# Green Hill Solar Farm

## EN010170

### Change Notification 2

Document Reference: CR2/GH9.4

Figure 4.10 Revision B
Green Hill Site A
Landscape and Ecology Mitigation Plan
(EN010170/EX3/GH6.4.4.10_B)
5/2(a)

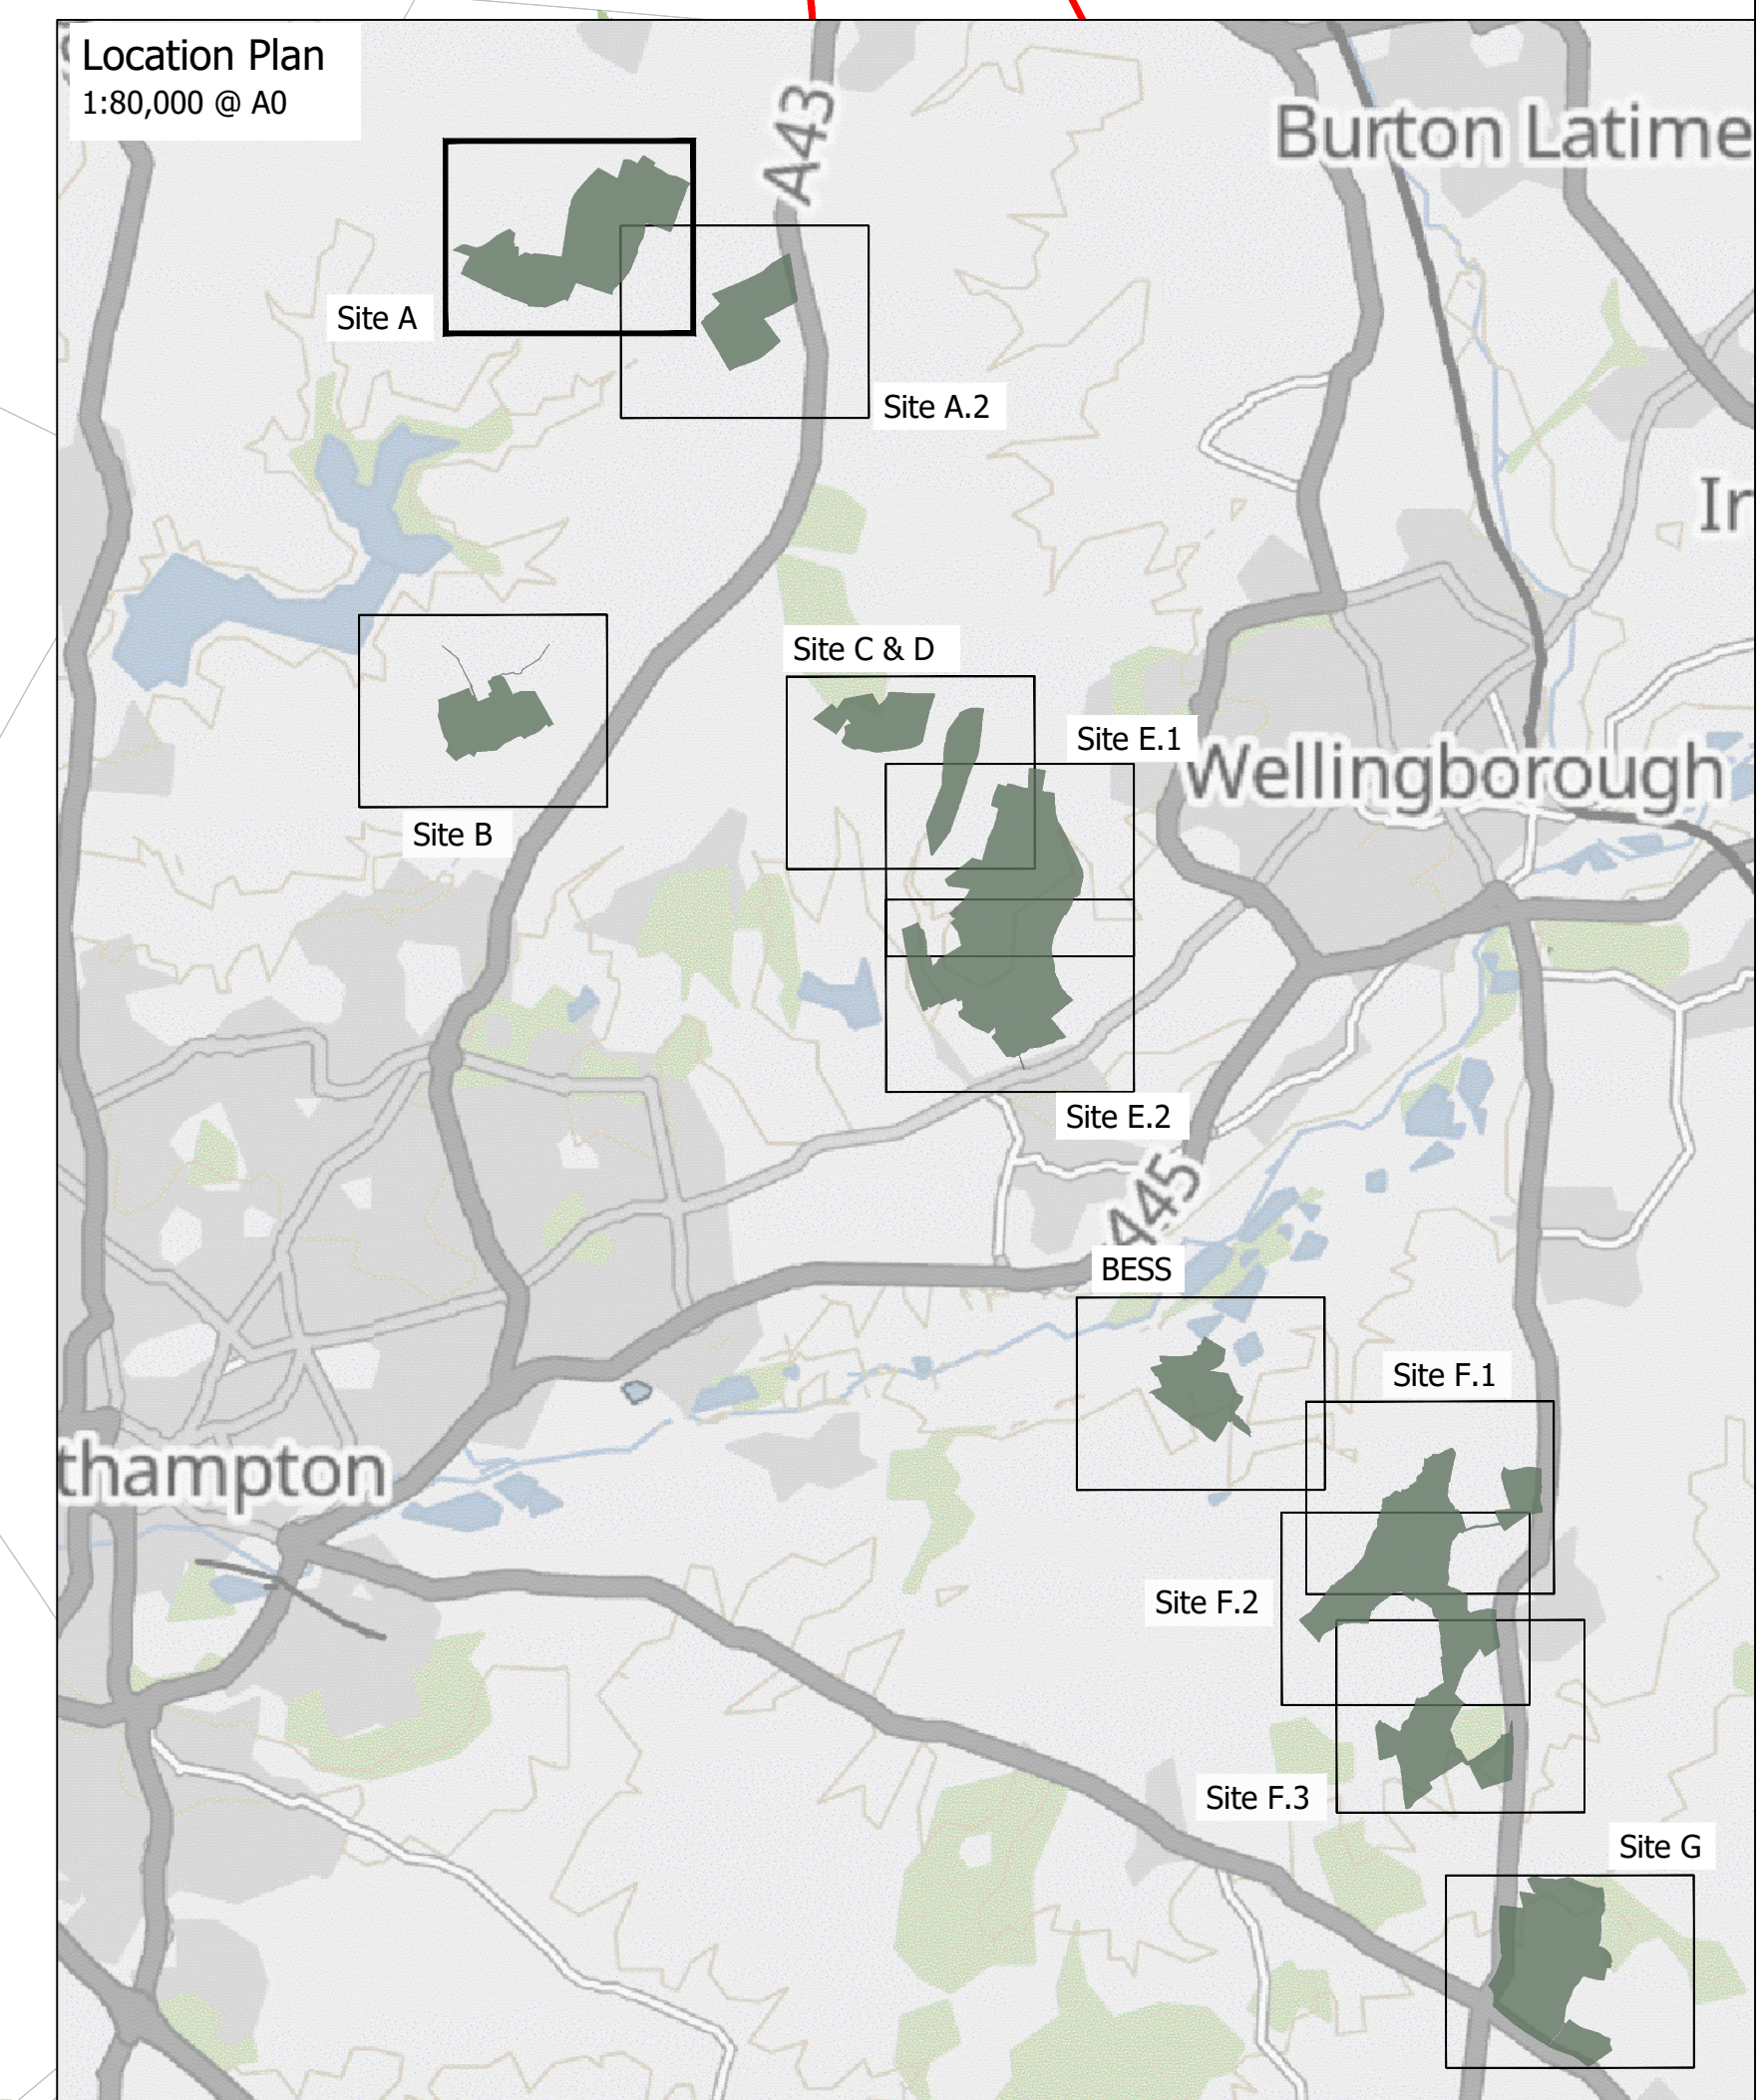
**2.5 Change 4: Removal of Panels (Work No.1) and reduction of Work No. 1(d) in AF29 and replaced with biodiversity mitigation and enhancement (Work Nos 9).**

- 2.5.1 Following publication of the Examining Authority's Schedule of Changes to draft Development Consent Order **[PD-015]**, the Applicant notes the Examining Authority's recommendation, under the comments on Work No. 1, for the removal of Work Nos. 1 and 1(d) from field reference AF29.
- 2.5.2 The Applicant has reviewed this recommendation and will implement the change accordingly.
- 2.5.3 Work No. 1 will be removed from field AF29 and the area of Work No. 1(d) has been reduced to the northern section of AF29. Cabling is required in this field to enable connection between fields AF10 (west of Newland Road) and AF14 and AF28 (east of Newland Road). Field AF29 will be proposed for biodiversity mitigation and enhancement under Work No 9. AF29 will be changed to skylark mitigation.
